CITY OF ALBUQUERQUE

July 22, 2019

Re: Solare Collegiate Charter School
8801 Gibson Blvd. SW 87121
Traffic Circulation Layout
Engineer's/Architect's Stamp 06-07-2019 (M09D031)

TCL

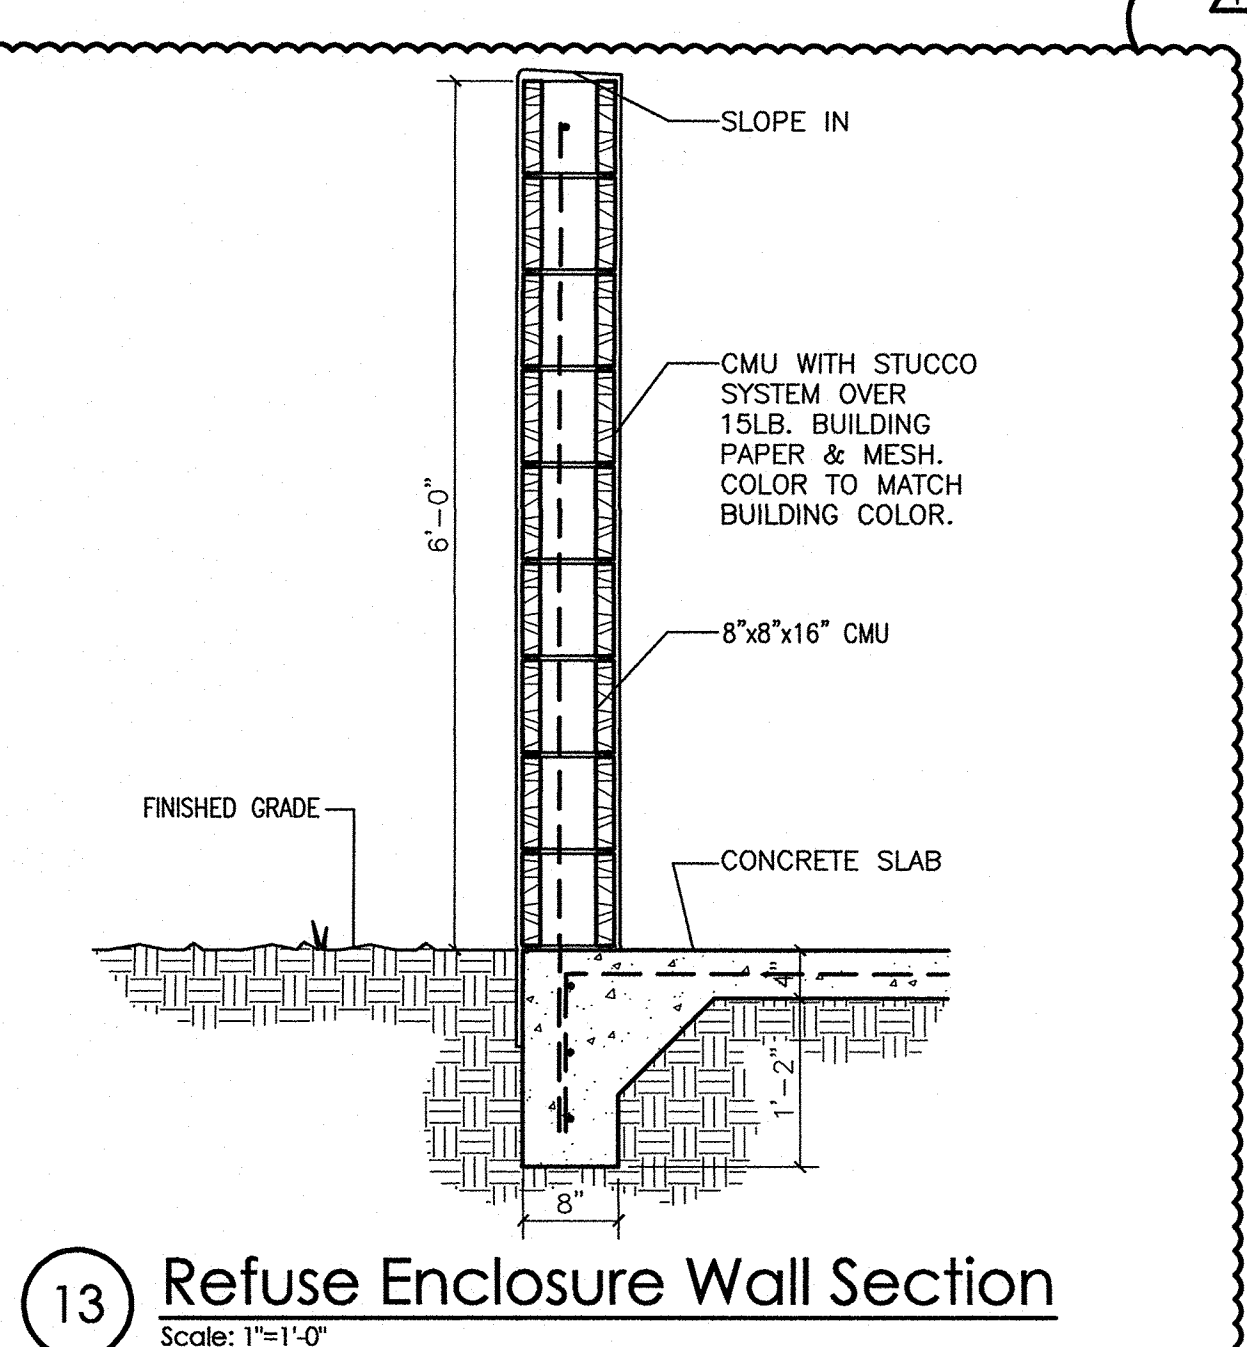
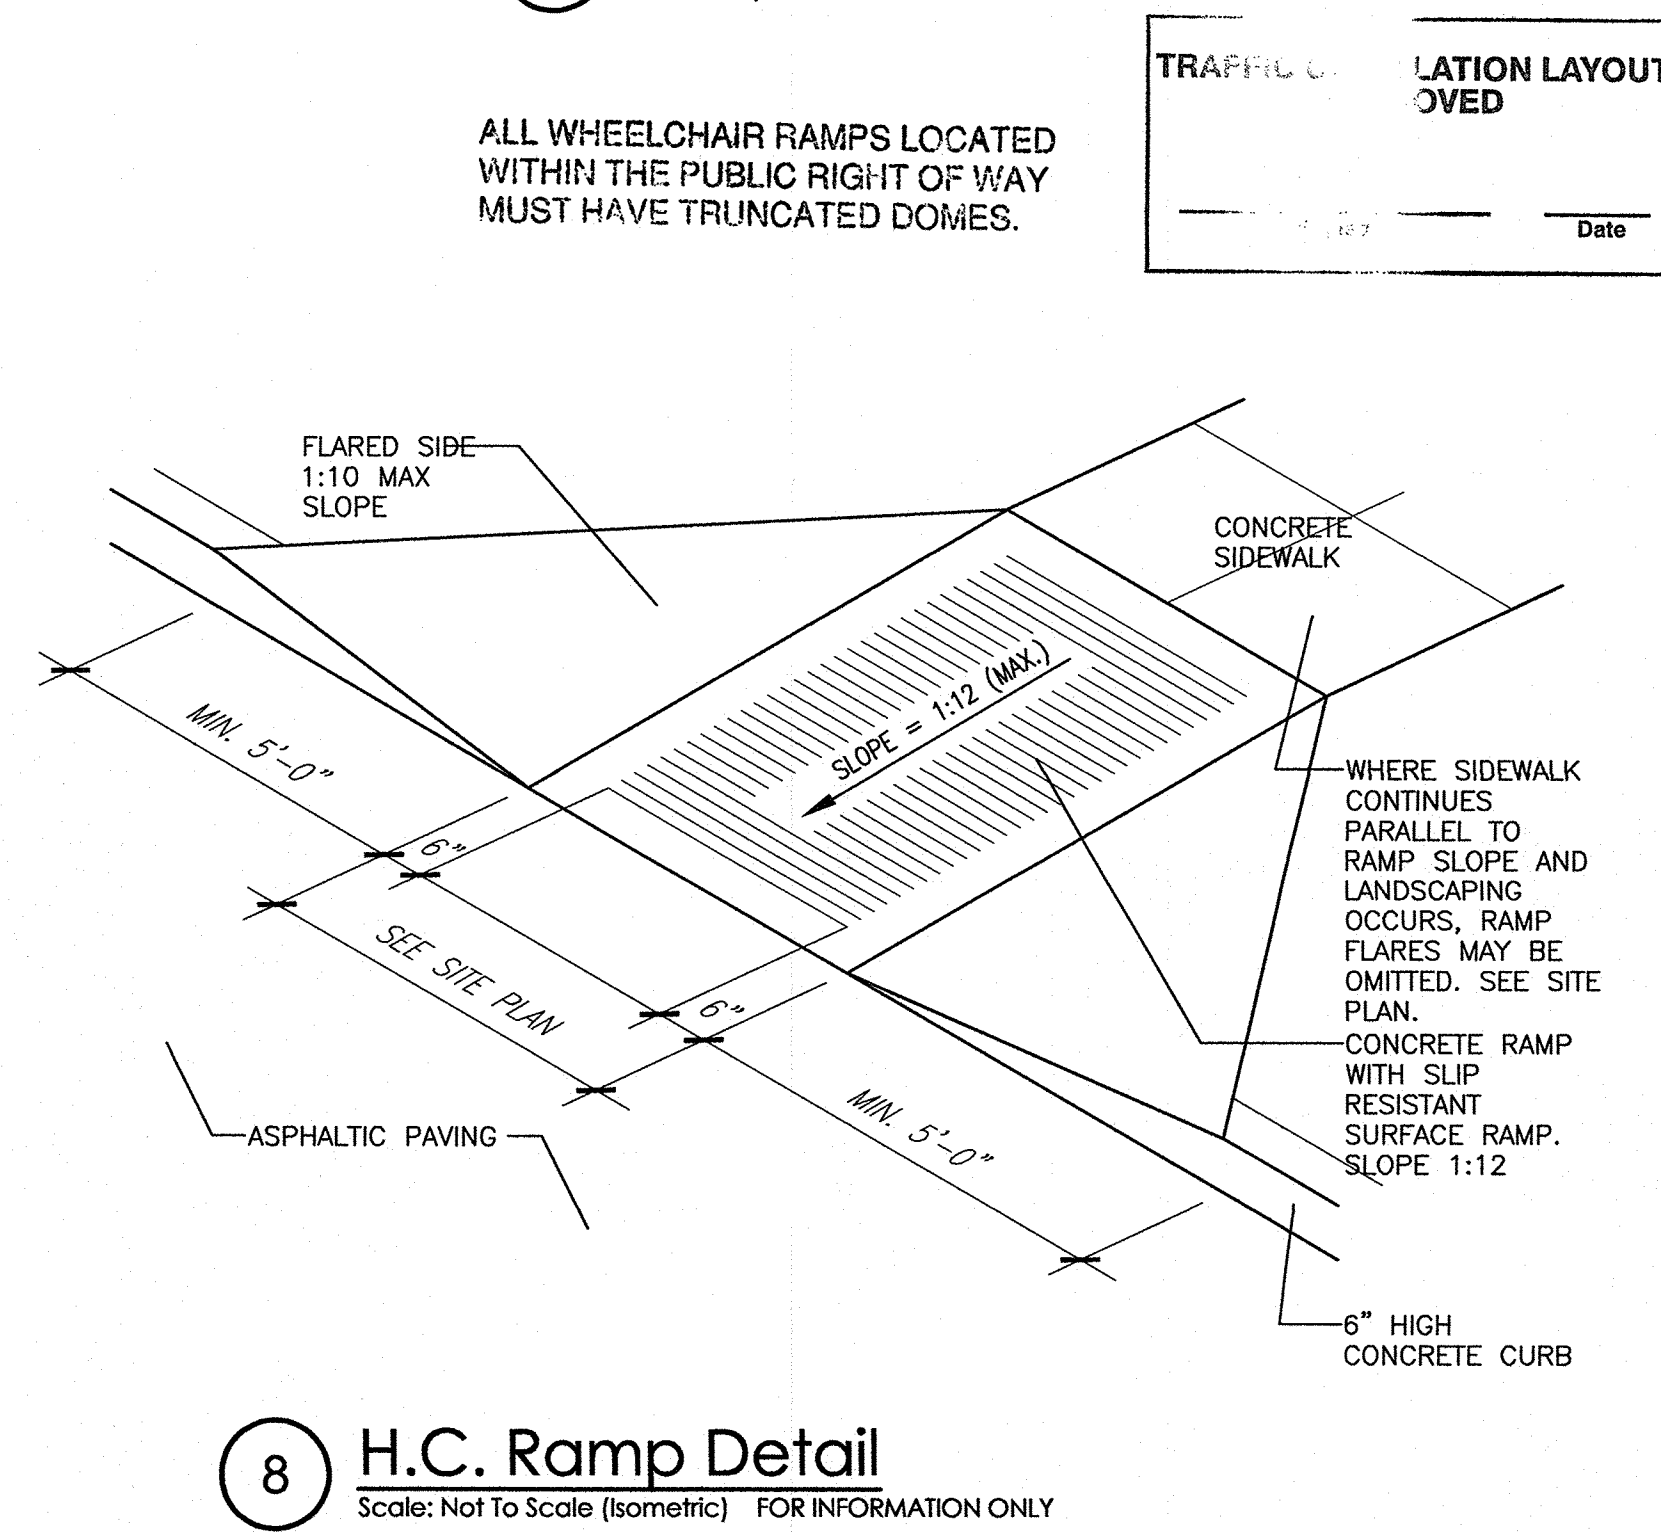
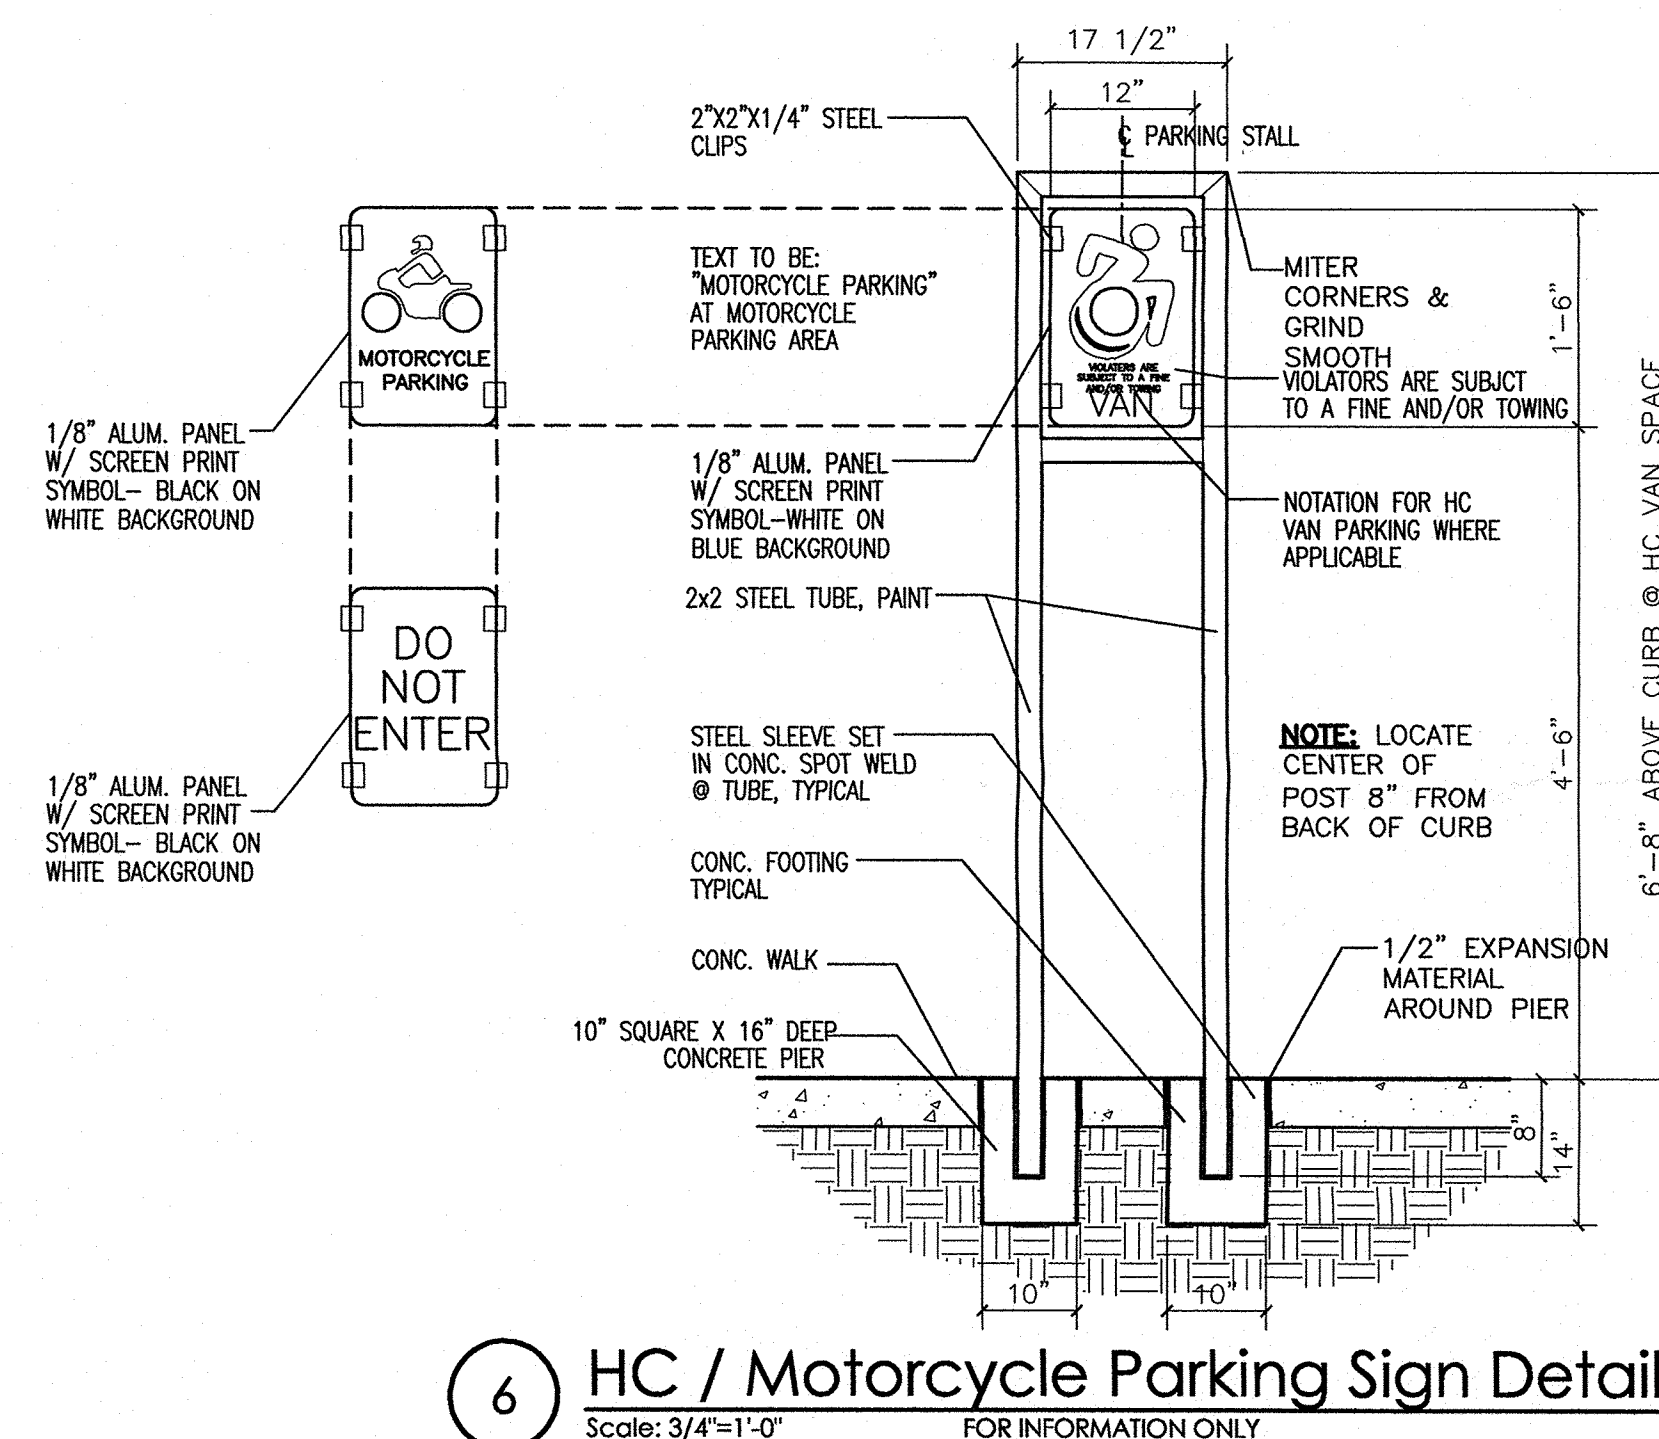
1. One-way vehicular paths require pavement directional signage and a posted "**Do Not Enter**" sign at the point of egress. Please show detail and location of posted signs.

2. Show the clear sight triangle and add the following note to the plan: "Landscaping and signage will not interfere with clear sight requirements. Therefore, signs, walls, trees, and shrubbery between 3 and 8 feet tall (as measured from the gutter pan) will not be acceptable in the clear sight triangle."

3. Please line up your access on Barbados Ave. SW with ranchers Rd. SW.
4. Provide notes showing what work is included and on the work order and the private work on site.

5. Work within the public right of way requires a work order with DRC approved plans.
6. Please add a note on the plan stating, "All improvements located in the Right of Way must be included on the work order."

7. Please match the infrastructure list with what is shown on TCL. The sidewalk on Barbados Ave SW is not shown in the infrastructure list.
